Application for a non-material amendment following a grant of planning permission.

Number	
Suffix	
Property name	Flint Barn
Address line 1	Peak Lane
Address line 2	
Address line 3	
Town/city	Kingston
Postcode	BN16 1RN
Description of site location must be completed if postcode is not known:	
Easting (x)	508036
Northing (y)	101660
Description

Reference number:	K/52/20/HH
Date of decision	27/01/2021

15 Mar 2021 - Flint Barn - NMA - Elevations

Proposed Elevations

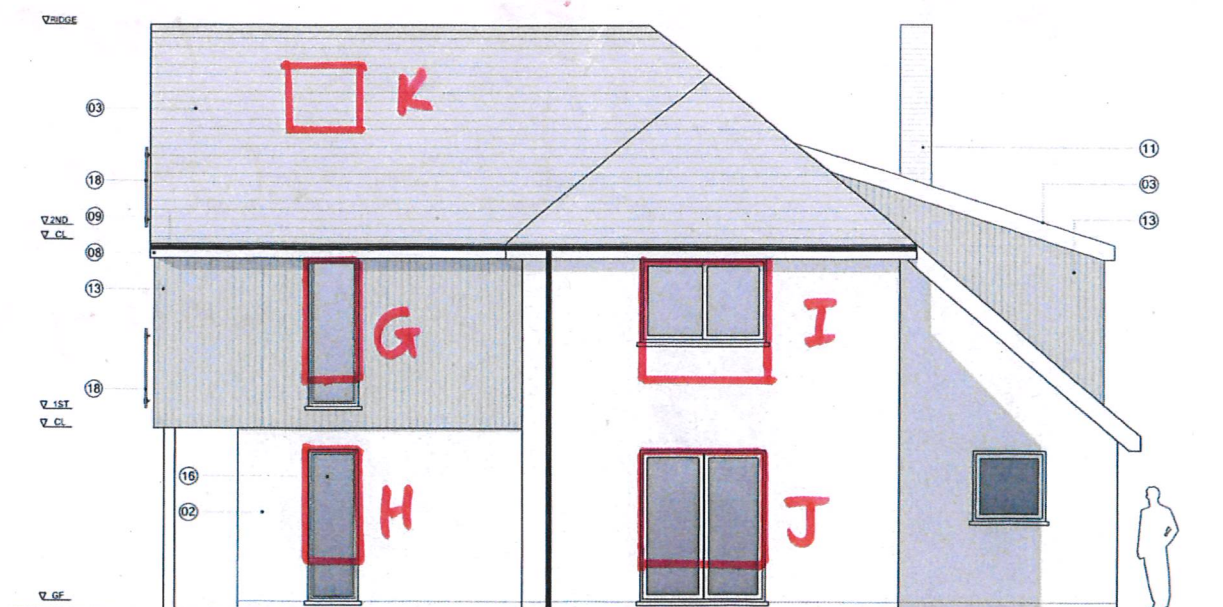
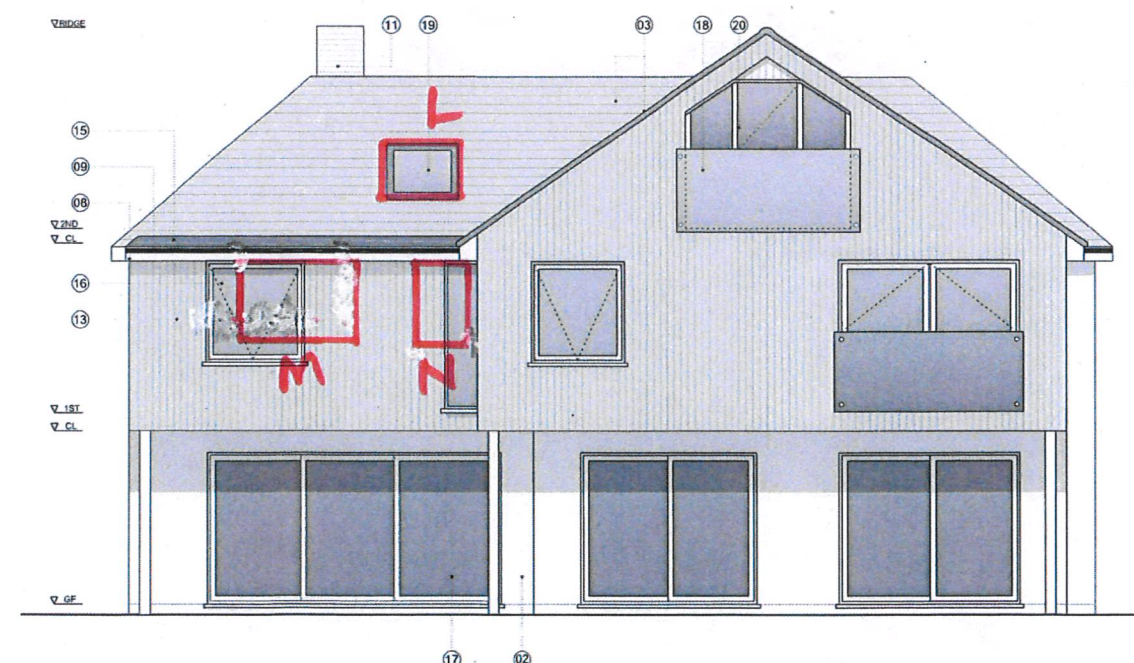
Alteration to a number of windows through reductions in size to reduce the extent of overlooking onto neighbouring properties and to reduce overall window replacement costs.
Amendment to the number of east facing windows in first floor master bedroom from quantity one to quantity 2, to improve outlook over open fields to the east.
Inclusion of quantity one additional supporting pillar on south elevation supporting first/second floor extension overhang to enable a reduction in steel mid beam by two thirds weight. This will ease logistics issues associated with access down a narrow lane (minimum 2-5 metres wide at narrowest point) and installation issues. Reducing the size/weight of this beam will remove the requirement to employ a crane on site to facilitate beam installation.

To reduce the extent of overlooking onto neighbouring properties.

To reduce overall window replacement costs.

To improve outlook over open fields to the east.

To reduce steel mid beam by two thirds weight - easing logistics issues associated with access down a narrow lane (minimum 2-5 metres wide at narrowest point) and remove the requirement to employ a crane on site to facilitate beam installation.
